Application H22-0077-25
Location Land off Broadgate Weston Hills Spalding
Proposal Rural exception site of 24 affordable homes

Name Stuart Greenfield
Address South Holland District Council - Building Control

Date Submitted 14-02-25
For/Against Comments

622.SL.01

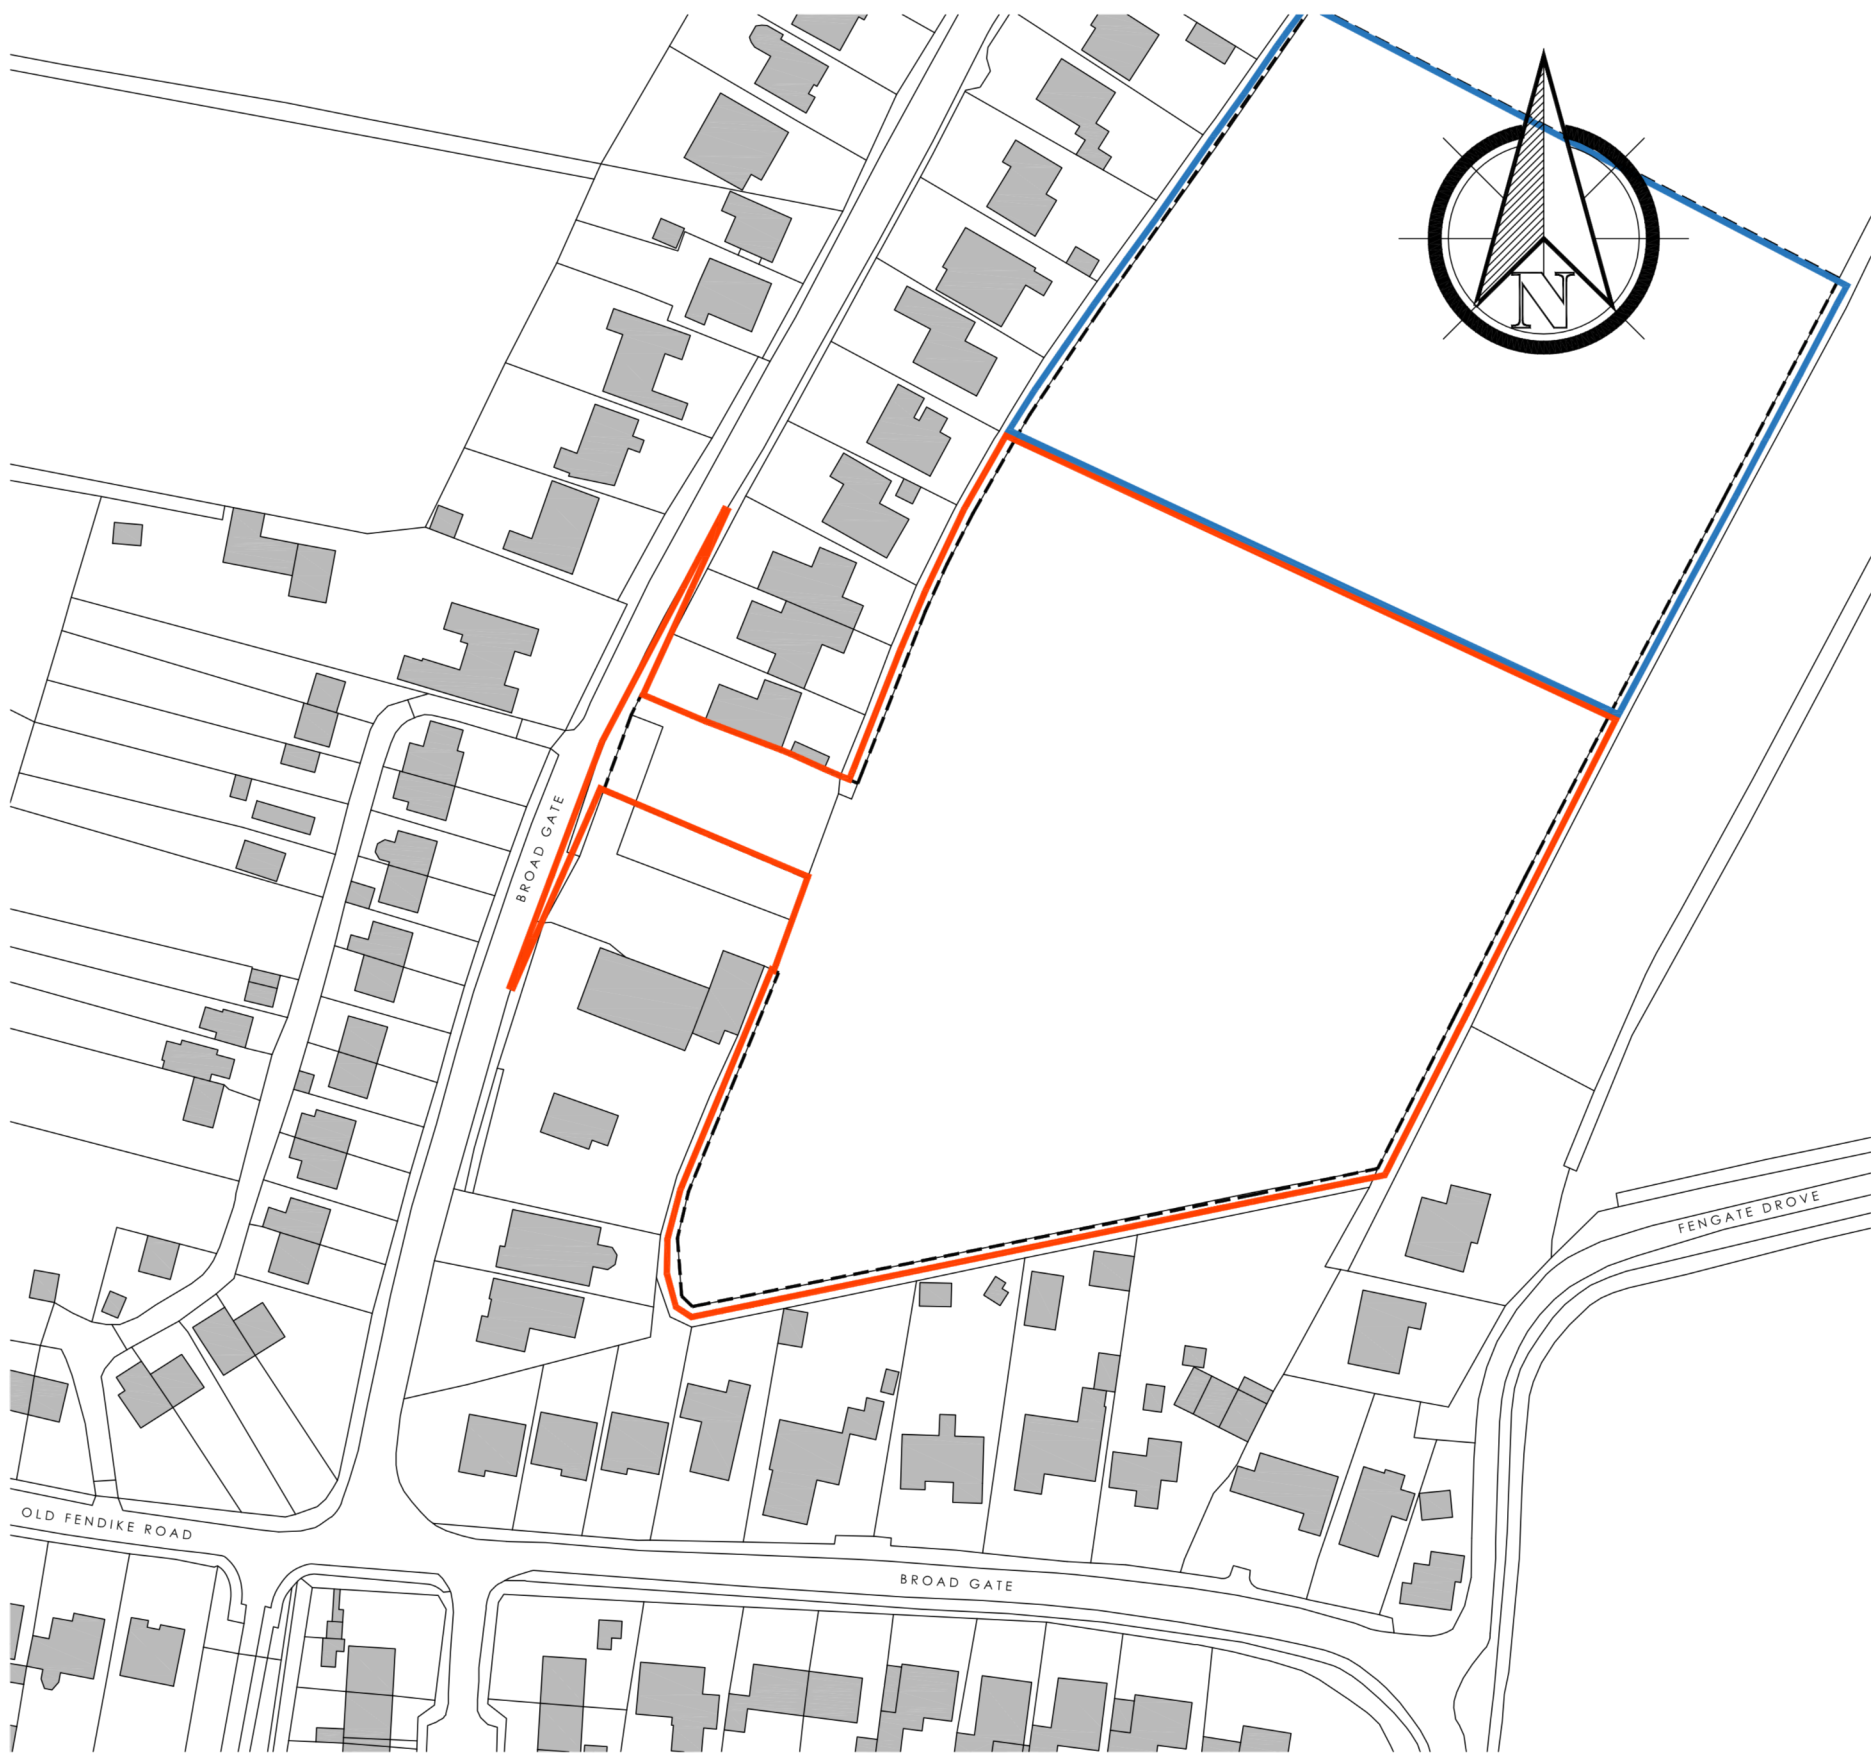
Private drives should have provision to support a Fire Appliance of 18 tonnes giving access to within 45m of all points inside the dwelling with a turning point provided where the appliance needs to reverse more than 20 metres to achieve this.

Solid waste storage areas should be sited so that the distance a householder is required to carry refuse does not exceed 30m. The storage area should then be sited within 25m of the waste collection point and should not interfere with pedestrian or vehicle access to buildings. Storage compounds should be secure to prevent access by vermin.
